From: Hebe Smith
Sent: 29 October 2025 14:58
To: Planning.Responses
Subject: FW: FP/135/25/PL - The Fox Inn, Waterloo Road
Attachments: Outlook-y4cm0oli; 25028-02A.pdf; The Fox - Revised window details.pdf; Action Sheet v6 FP-135.docx

From: Tom Wild <[REDACTED]>
Sent: 29 October 2025 14:35
To: Hebe Smith <Hebe.Smith@arun.gov.uk>
Subject: FP/135/25/PL - The Fox Inn, Waterloo Road

## The Fox (Amended designs in white)

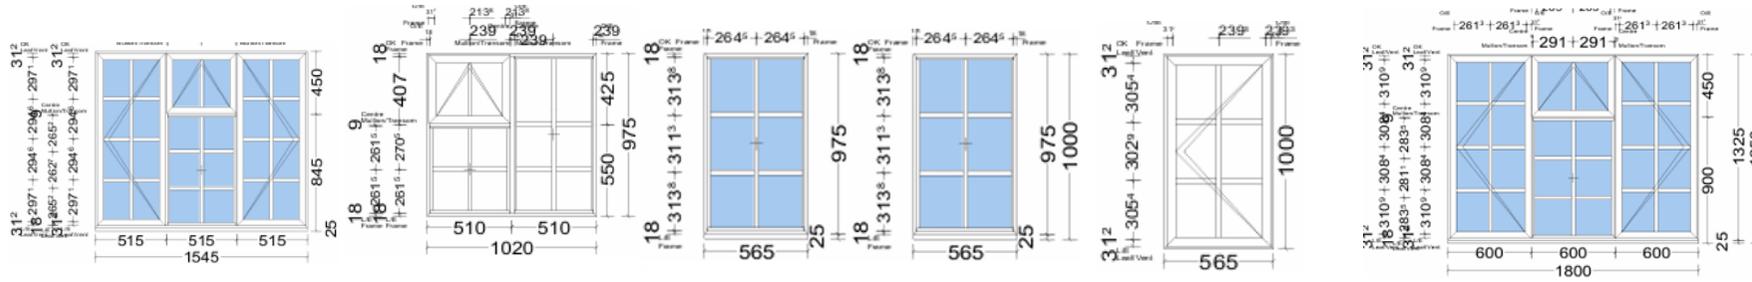
- Retain the existing curved bay window to the front elevation. This maintains the distinctive feature of the building to preserve its character and contribution to the street scene.
- Transom and glazing bars in the rear elevation have been updated to replicate and maintain the existing pattern and arrangement.
- A vertical glazing bar has been added to the top hung quarter lights in the front elevation to replicate and maintain the existing pattern and arrangement.
